From: Tom Errico <thomas.errico@tylin.com>
To: Jean Fraser <JF@portlandmaine.gov>
Date: 8/4/2014 3:28 PM
Subject: 122 Anderson Street

Jean - I reviewed the application materials for the project and offer the following final comments and conditions of approval for the project.

DIRECTIONS TO THE INTERMODAL TRUCK STAGING YARD:

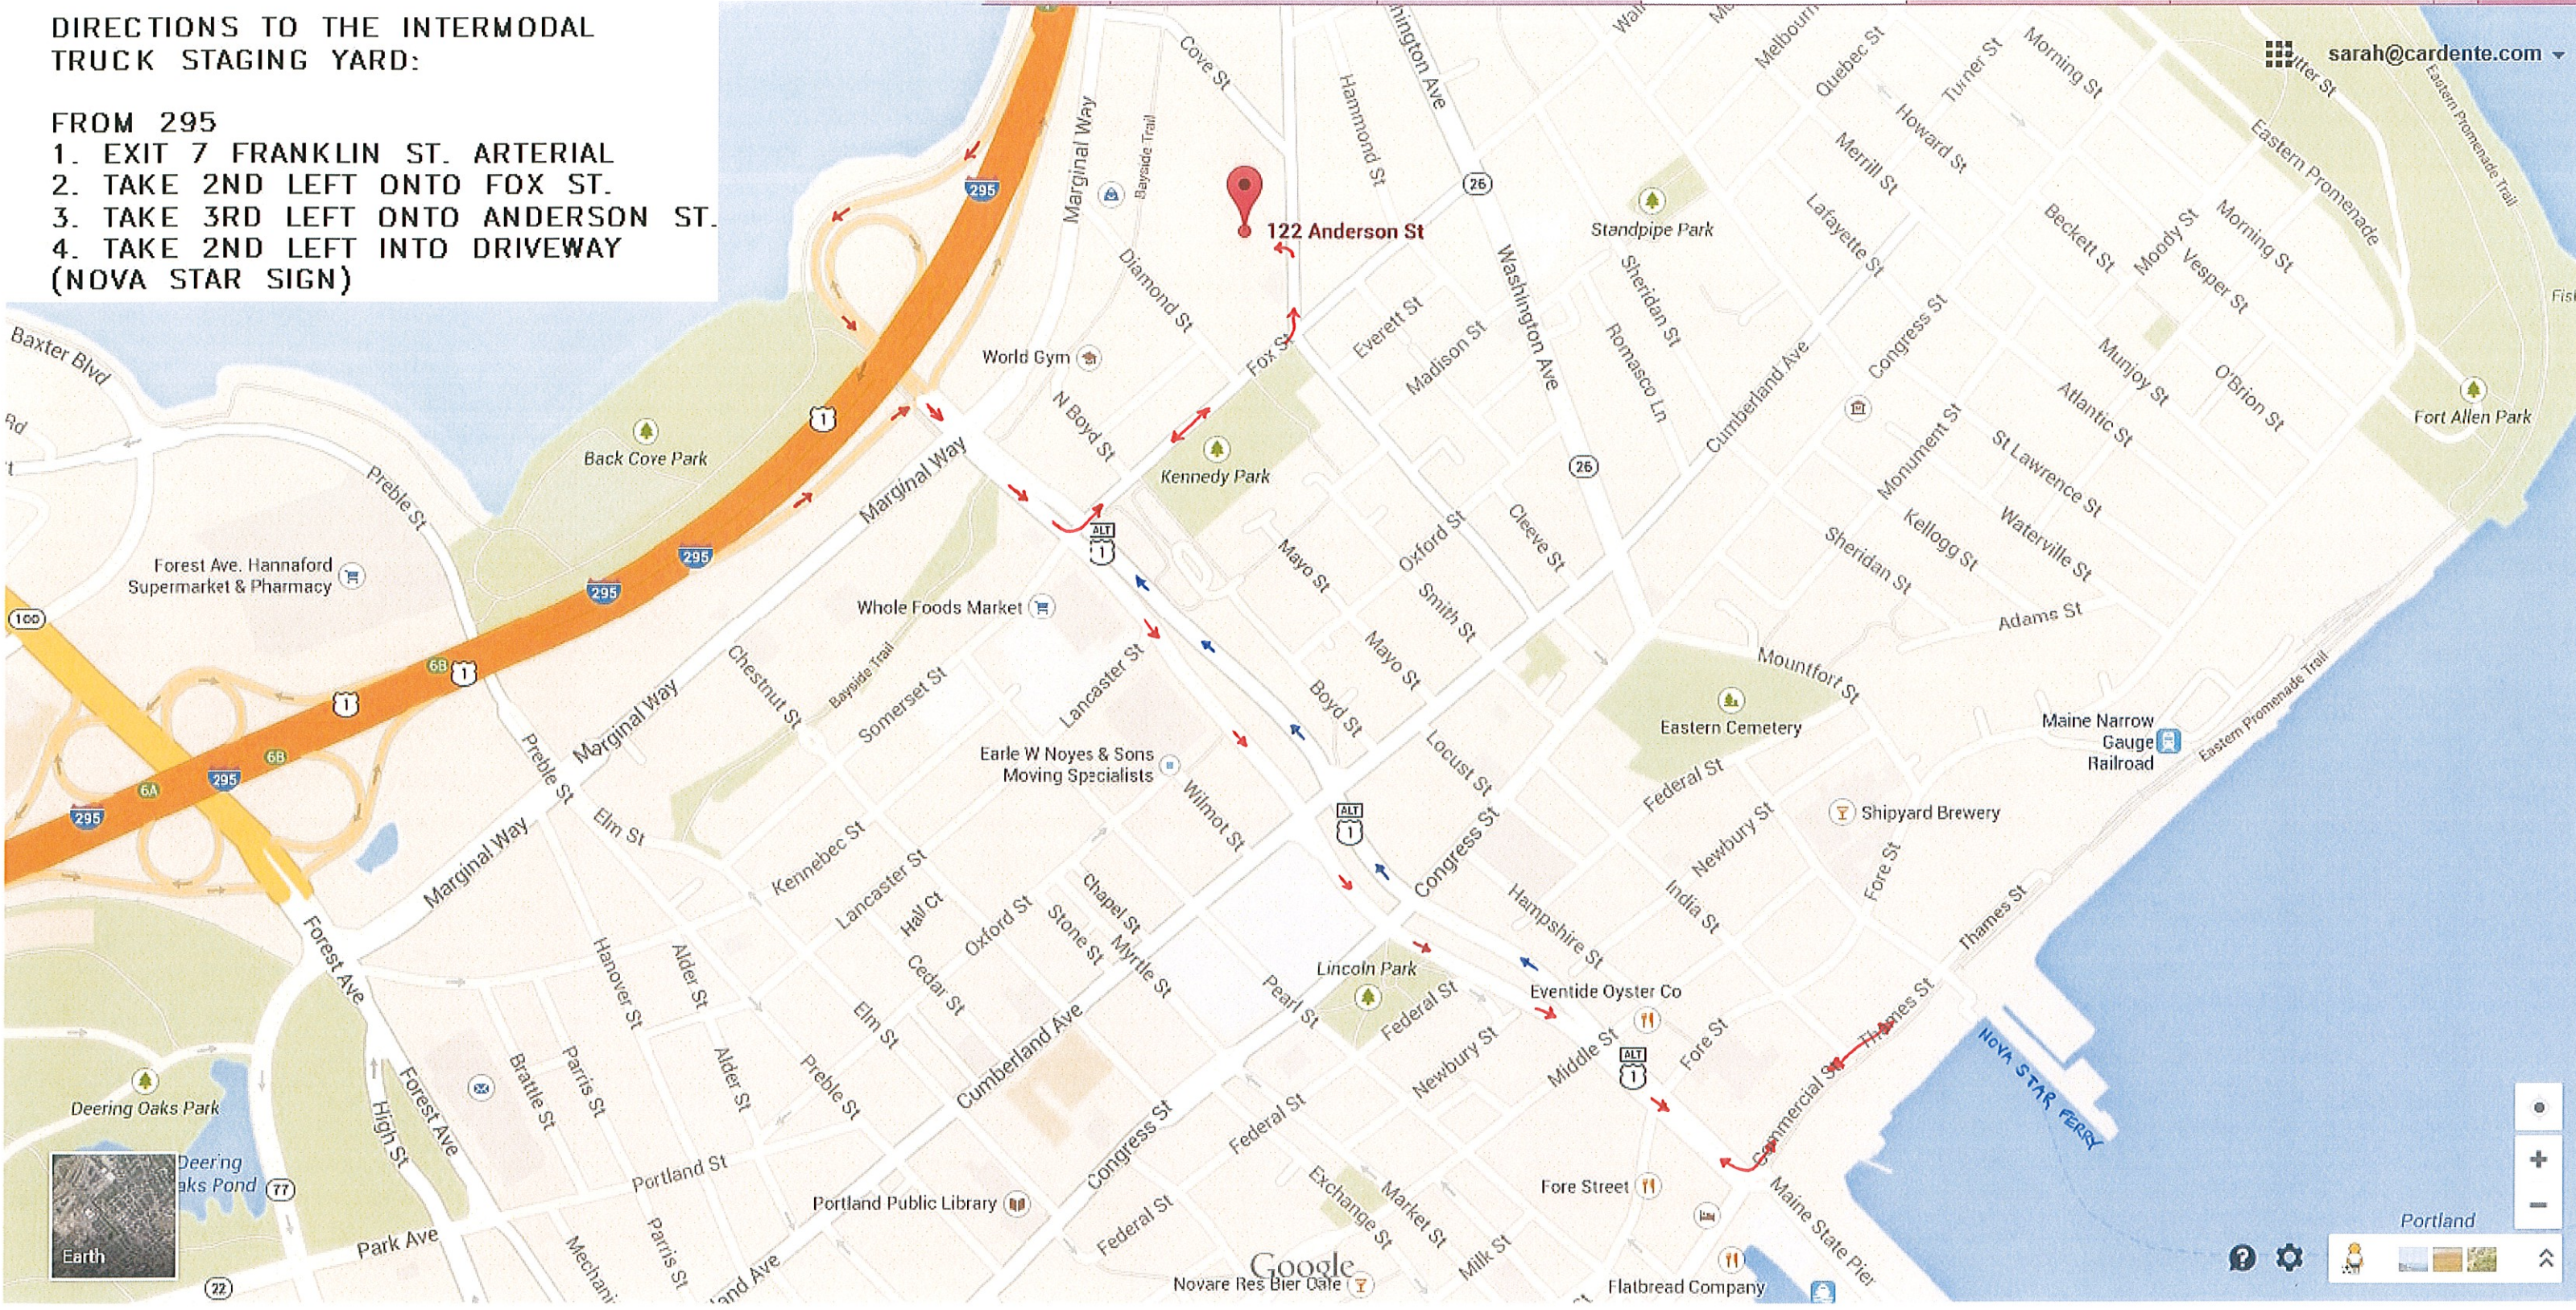
* The applicant has suggested a routing plan from 122 Anderson Street to Fox Street and Franklin Street. I find this routing to be reasonable given the driveway geometric alignment (left-turn exit movements and right-turn entry movements would be problematic). Accordingly, the following recommendations are based upon this routing.

* The applicant shall implement a departure management plan that limits the truck departure rate to a one truck per minute or more. The westbound Fox Street signal phase at Franklin Street will not likely be able to process more than one truck and therefore is currently a limiting factor. The monitoring study will review this departure rate and recommend adjustments, as necessary.

**C1.3**

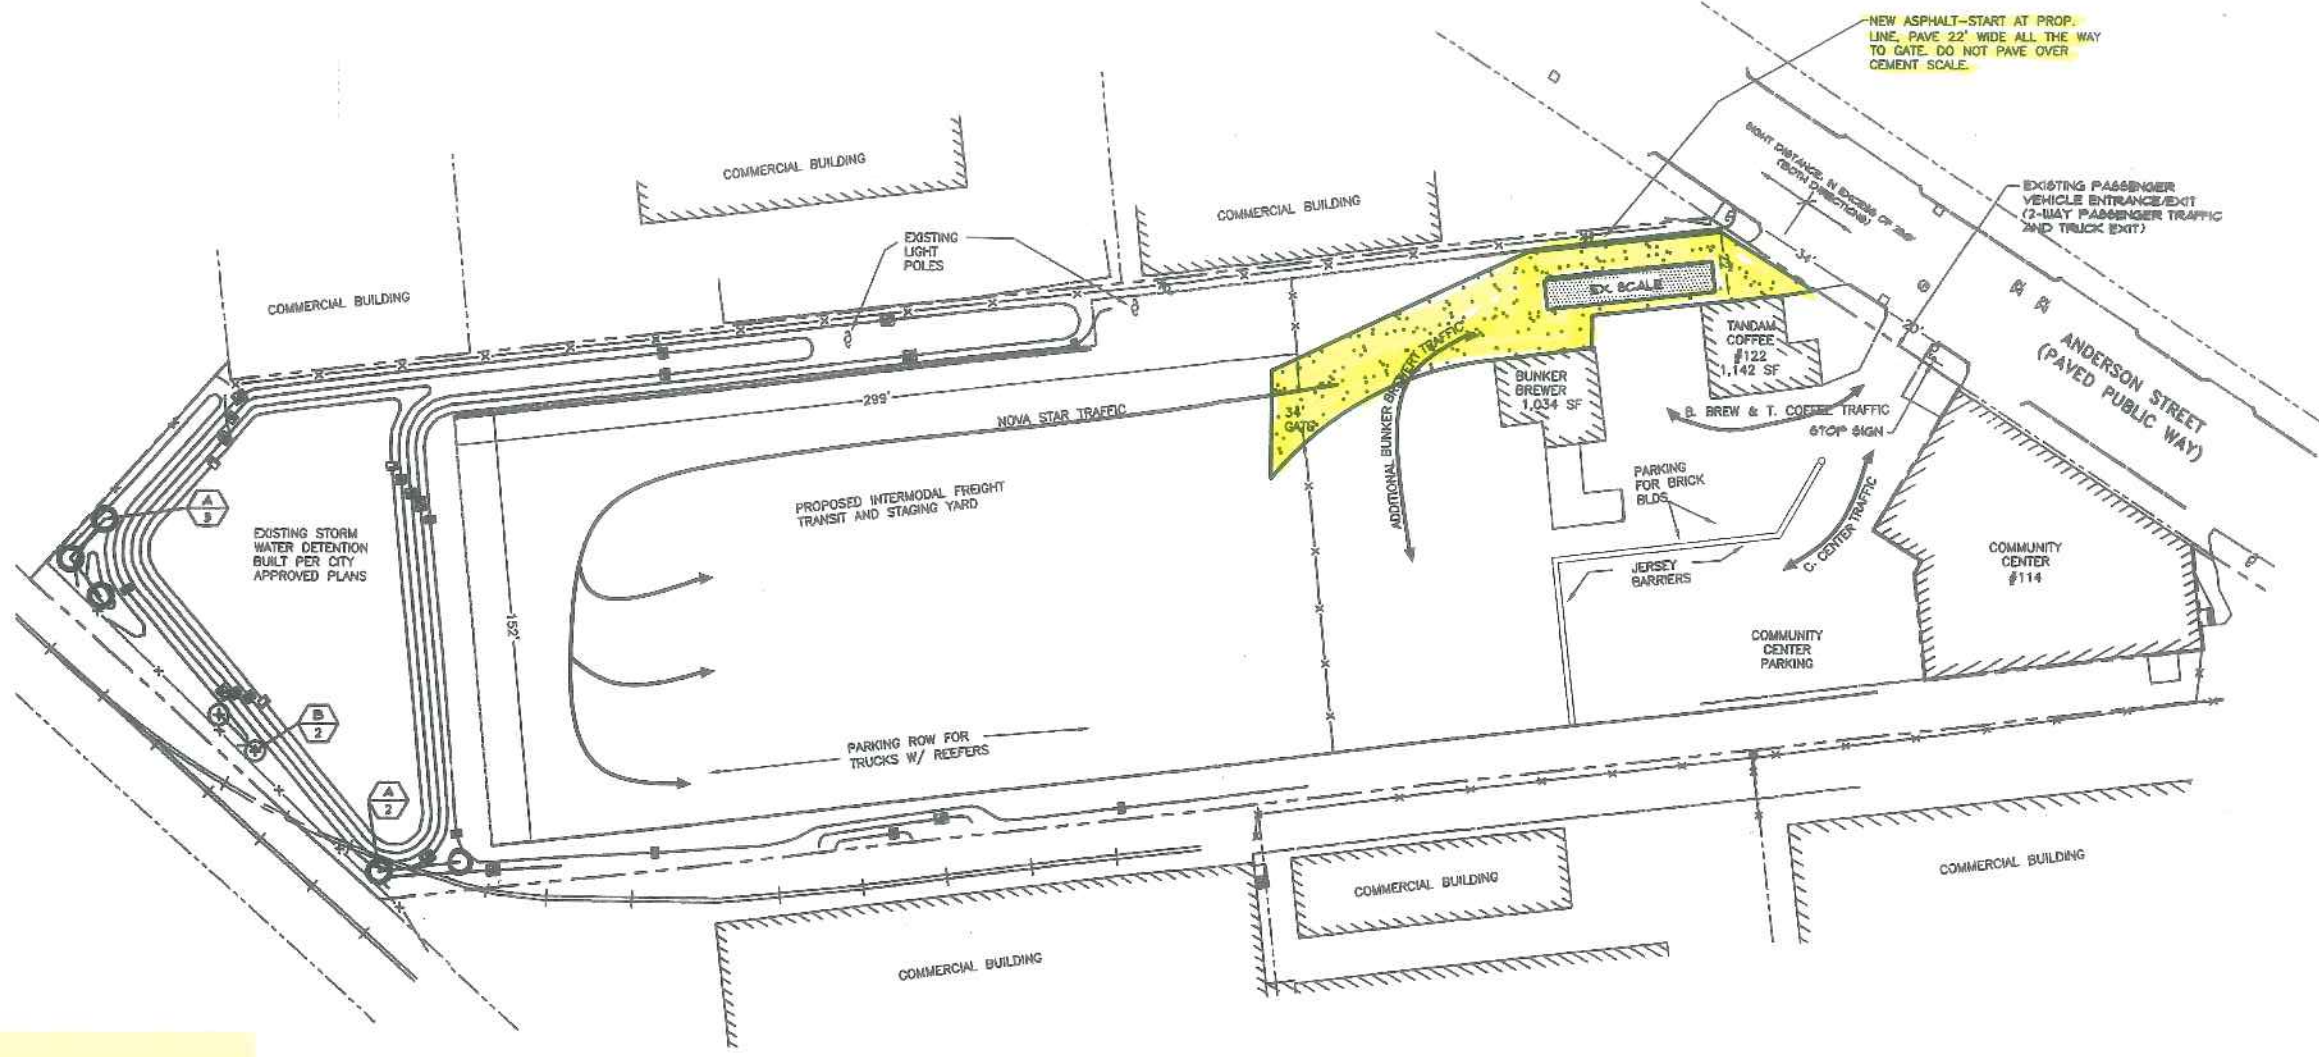
* The applicant shall be responsible for providing a fully paved driveway of a minimum width of 22 feet wide from the right-of-way boundary extending into the site for 50 feet. A plan of this improvement shall be provided for review and approval.
